8765 & 8815 Vollmer Road, VR-23-12

Please accept the following comments from El Paso County Public Health regarding the project referenced above:

Mike McCarthy
El Paso County Public Health
719.575.8602
mikemccarthy@elpasoco.com
23June2023

AS-REPLATTED

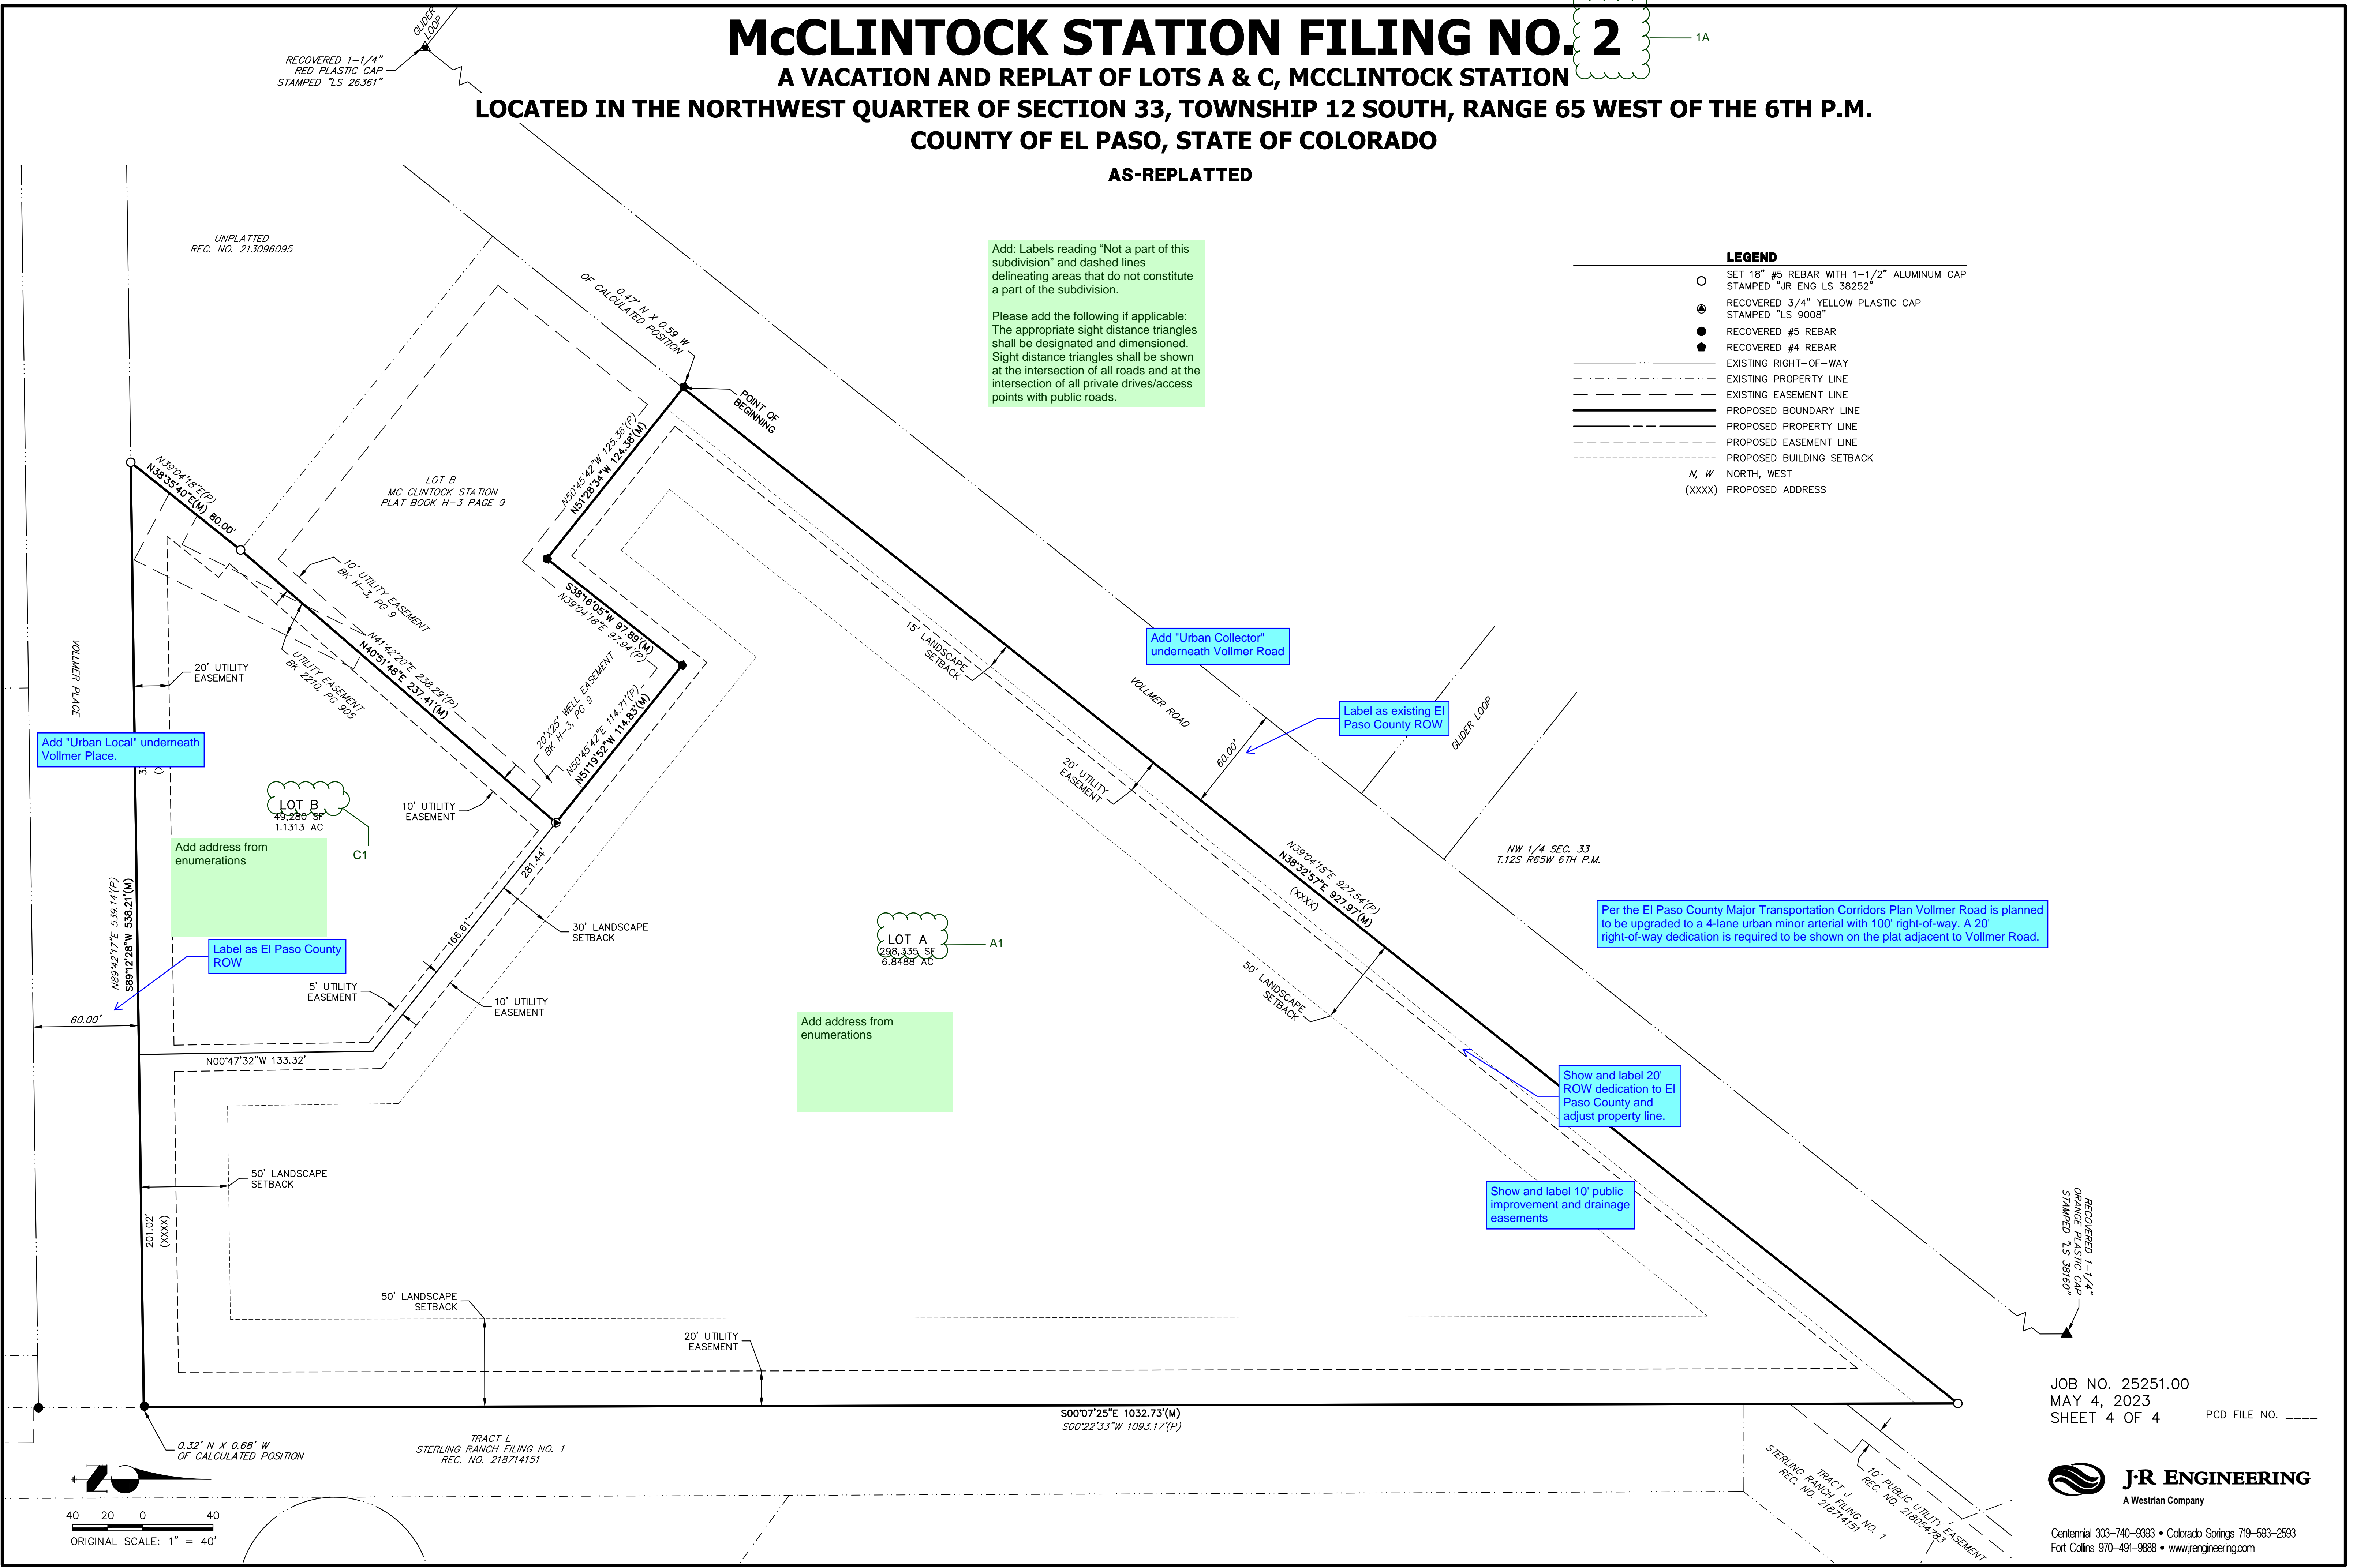
- **The rezone was between Lot A and Lot C, but the Vacation and Replat drawings show two Lot B's.**
- **The more southerly 1.1313-acre Lot B appears to be the former Lot C.**
- **The 1.1313-acre Lot B cannot be approved unless it can be verified that a private well and a new onsite wastewater treatment system (OWTS) can be installed that meets all the requirements of the El Paso County Public Health Onsite Wastewater Treatment System Regulations. This includes sufficient area for both a Primary and a Secondary soil treatment area.**
- **Please verify with Development Services that a 1.1313-acre lot on a private well and onsite wastewater treatment system can even be created.**
- **No issues noted with the rezone for Lot A.**
